CITY OF ALBUQUERQUE

**Re: New Sherwin Williams
5731 Mc Mahon Blvd. NW
30-Day Temporary Certificate of Occupancy- Transportation Development
Transportation Development Final Inspection
Engineer's Stamp dated 6-28-17 (A11D012A)
Certification dated 1-18-18**

Based upon the information provided in your submittal received 1-18-17, Transportation Development has no objection to the issuance of a 30-day Temporary Certificate of Occupancy. This letter serves as a "green tag" from Transportation Development for a 30-day Temporary Certificate of Occupancy to be issued by the Building and Safety Division.

Prior to the issuance of a permanent Certificate of Occupancy, the following items must be addressed:

AS-BUILT SITE PLAN for TRANSPORTATION DEVELOPMENT

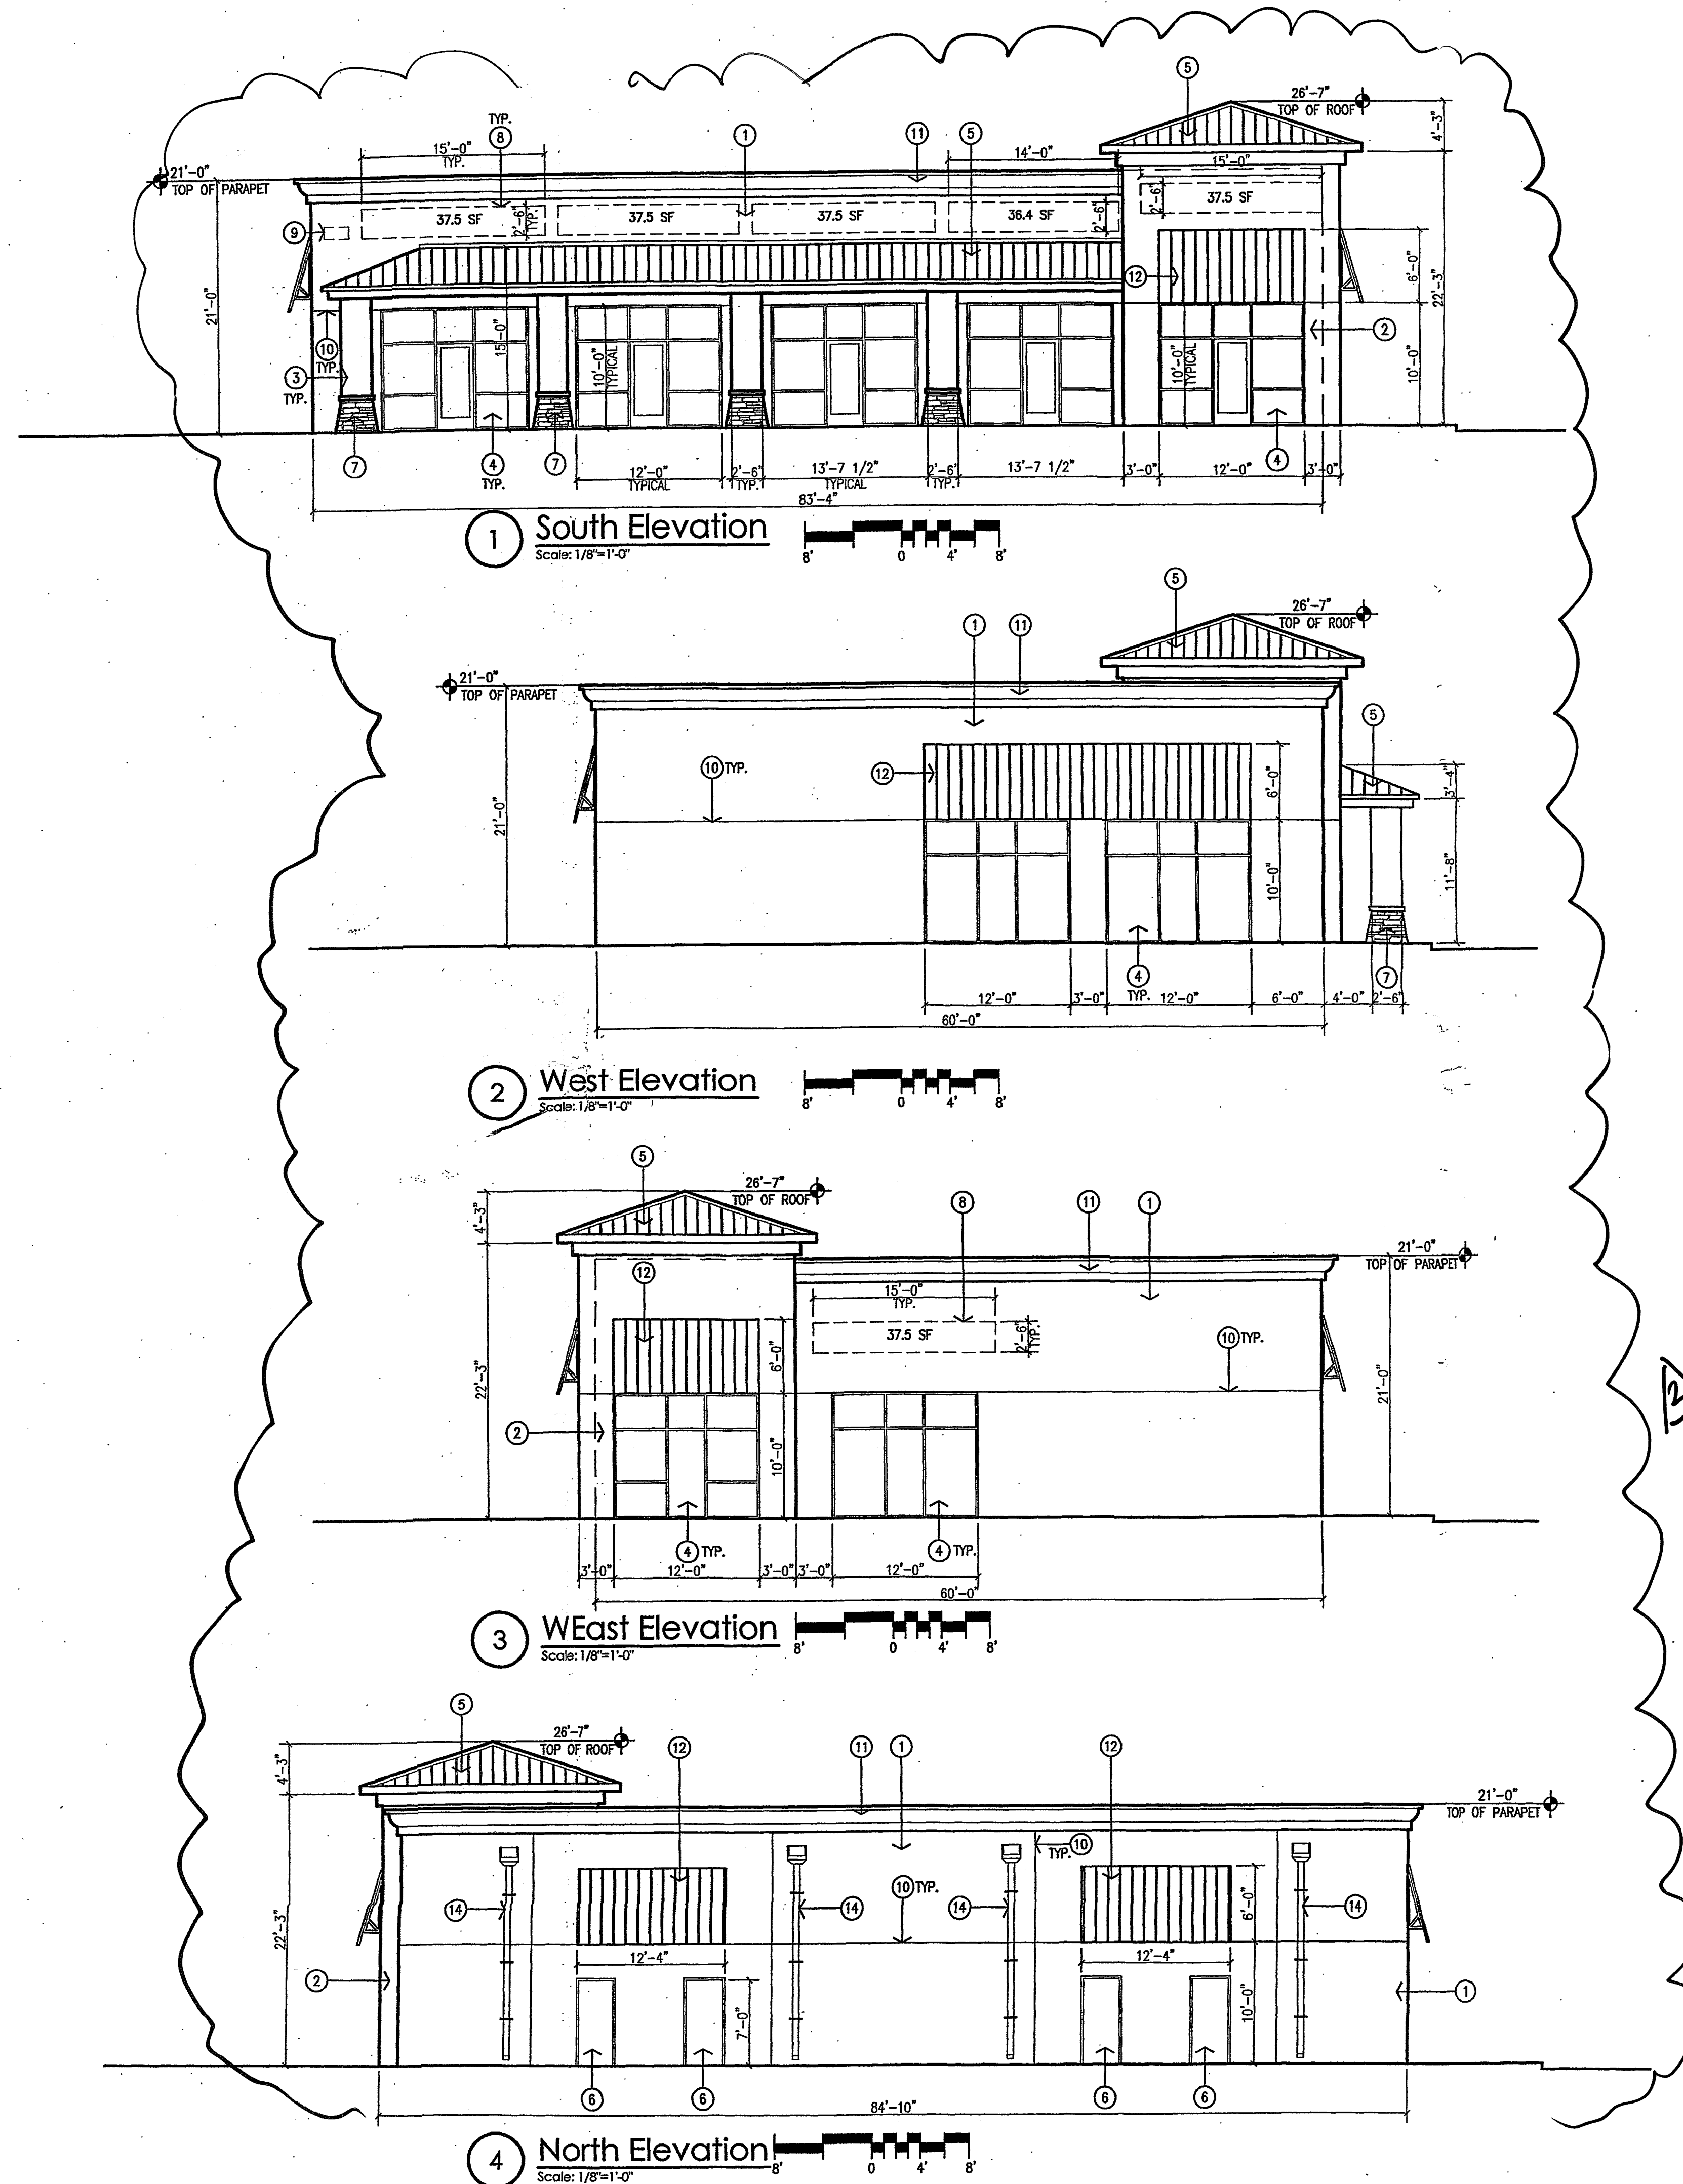
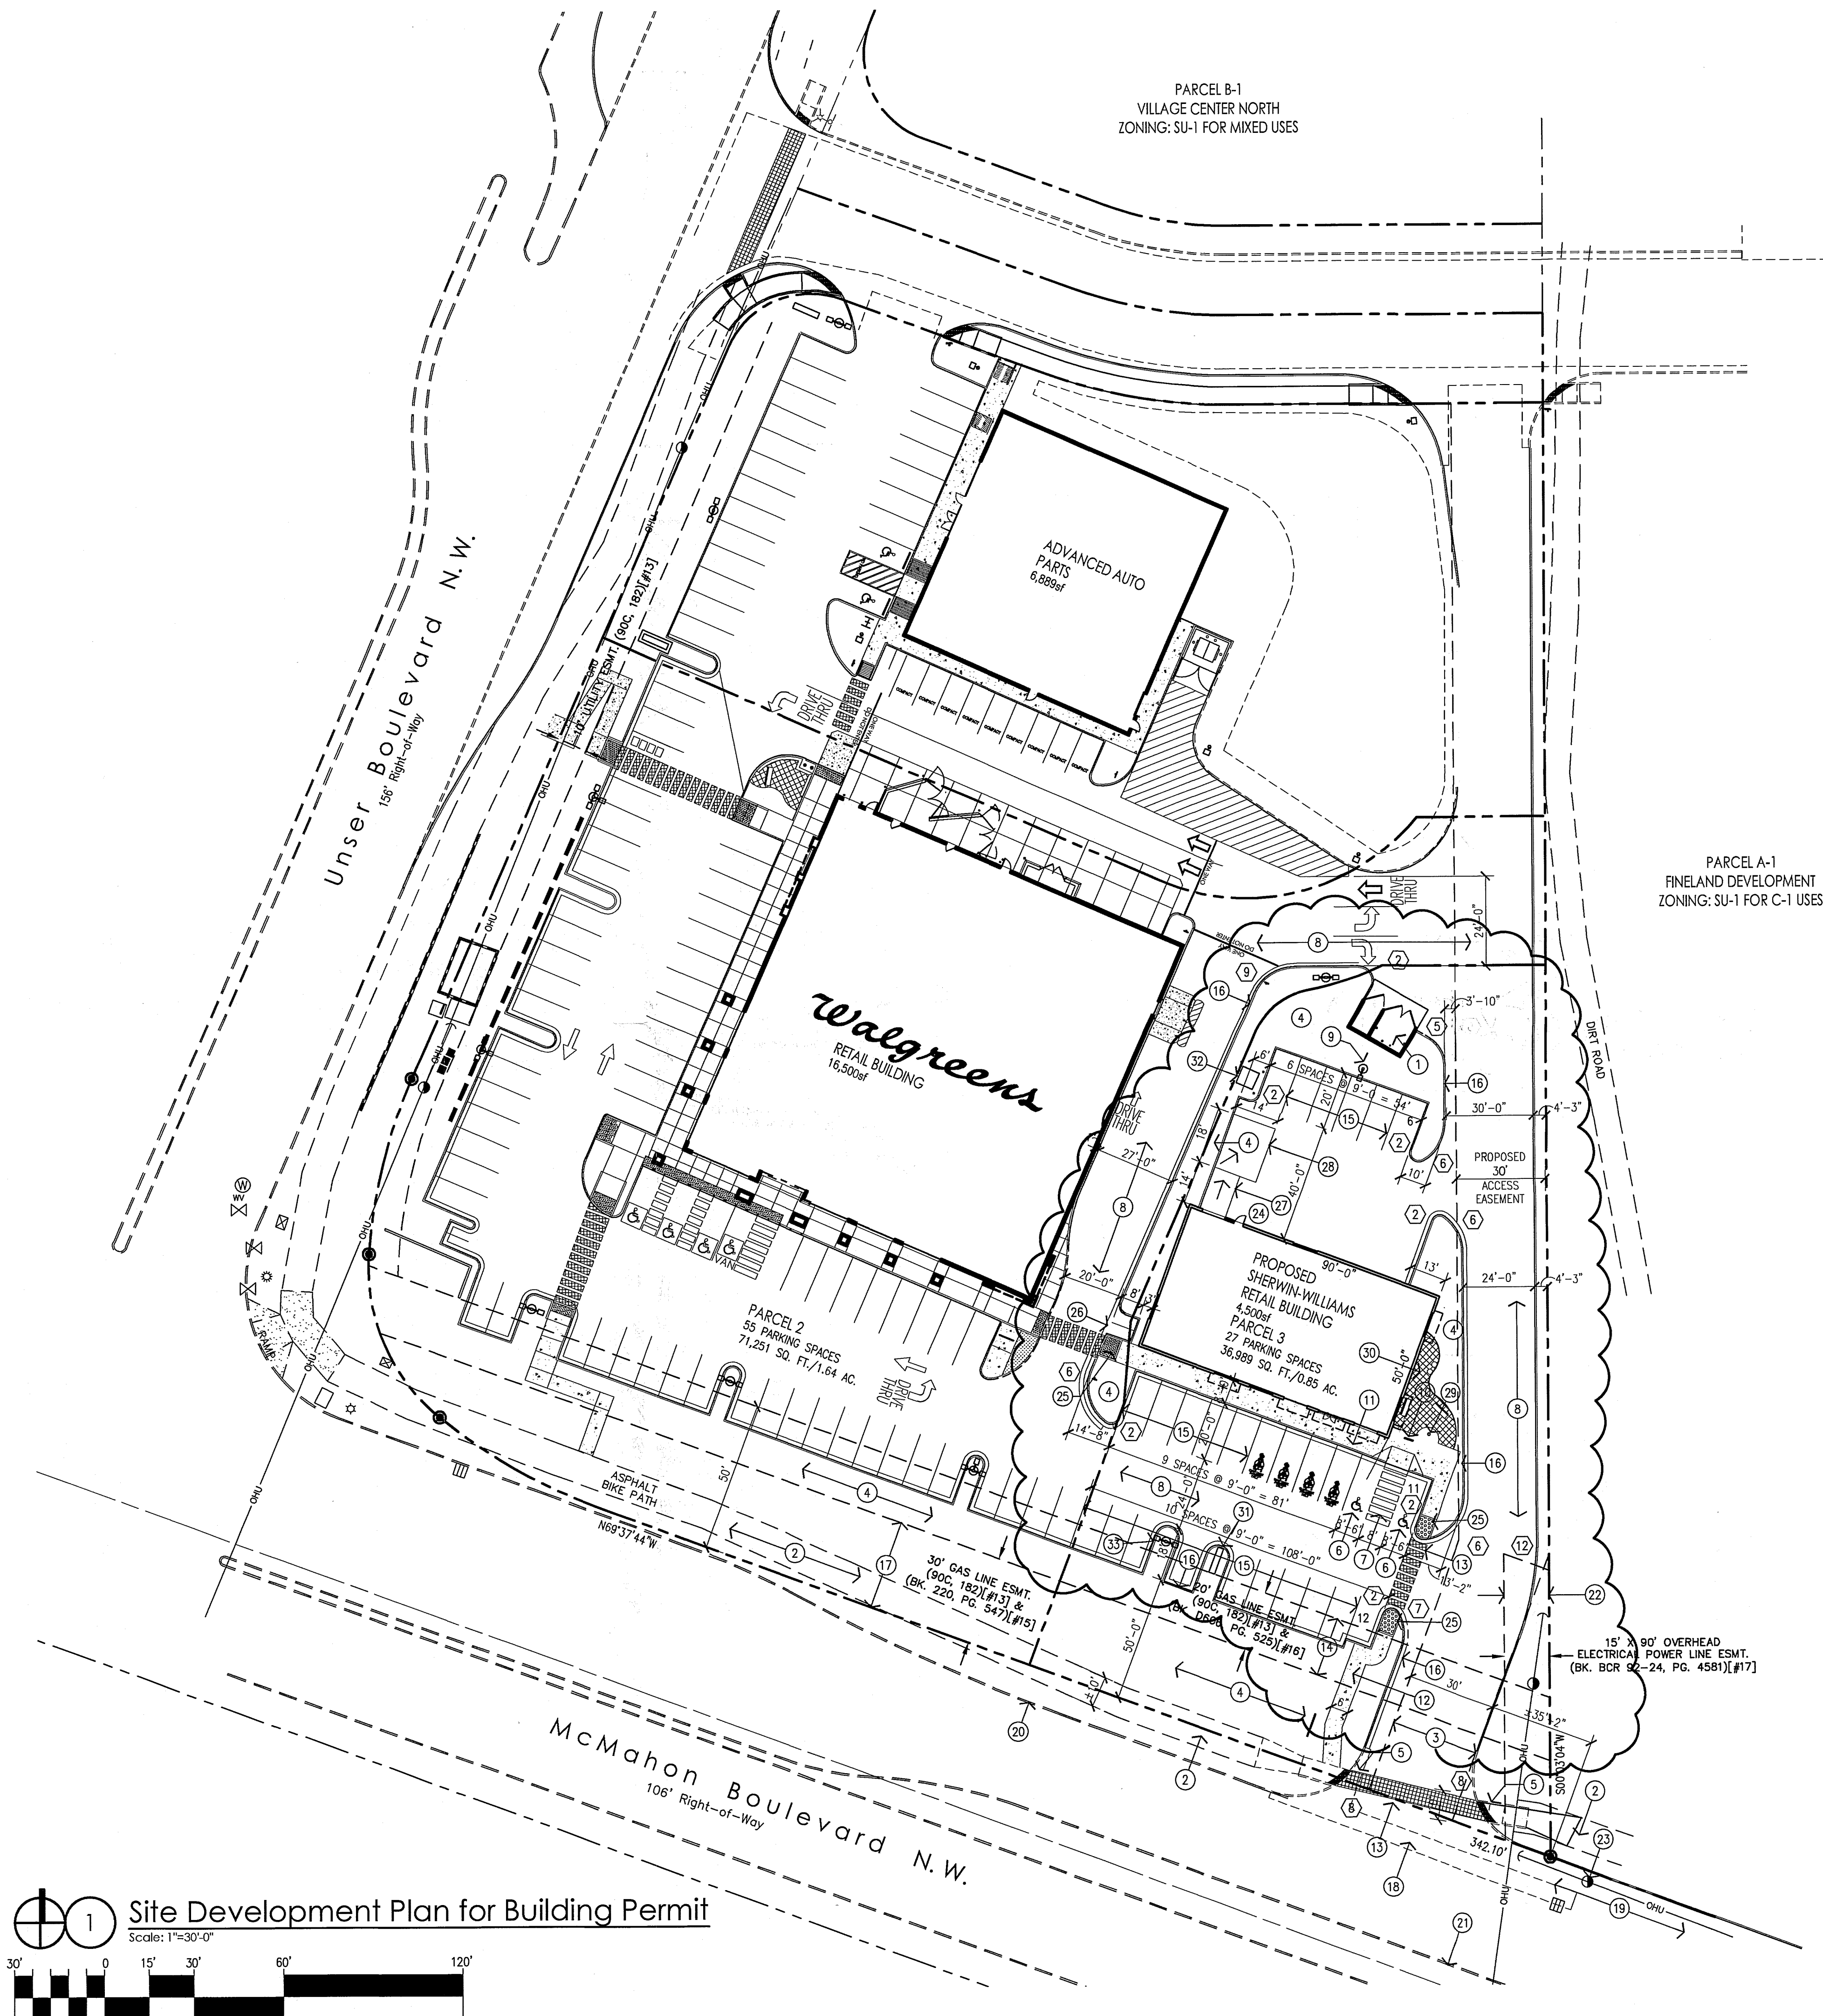
1. The ADA accessible parking sign must have the required language per 66-7-352.4C NMSA 1978 "Violators Are Subject to a Fine and/or Towing." Please call out detail and location of HC signs.
2. The ADA access aisles shall have the words "NO PARKING" in capital letters, each of which shall be at least one foot high and at least two inches wide, placed at the rear of the parking space so as to be close to where an adjacent vehicle's rear tire would be placed. (66-1-4.1.B NMSA 1978)
3. It appears there are some changes in the location of ADA Parking Spaces and Motorcycles Parking Spaces, please Red Mark these changes on the site plan.
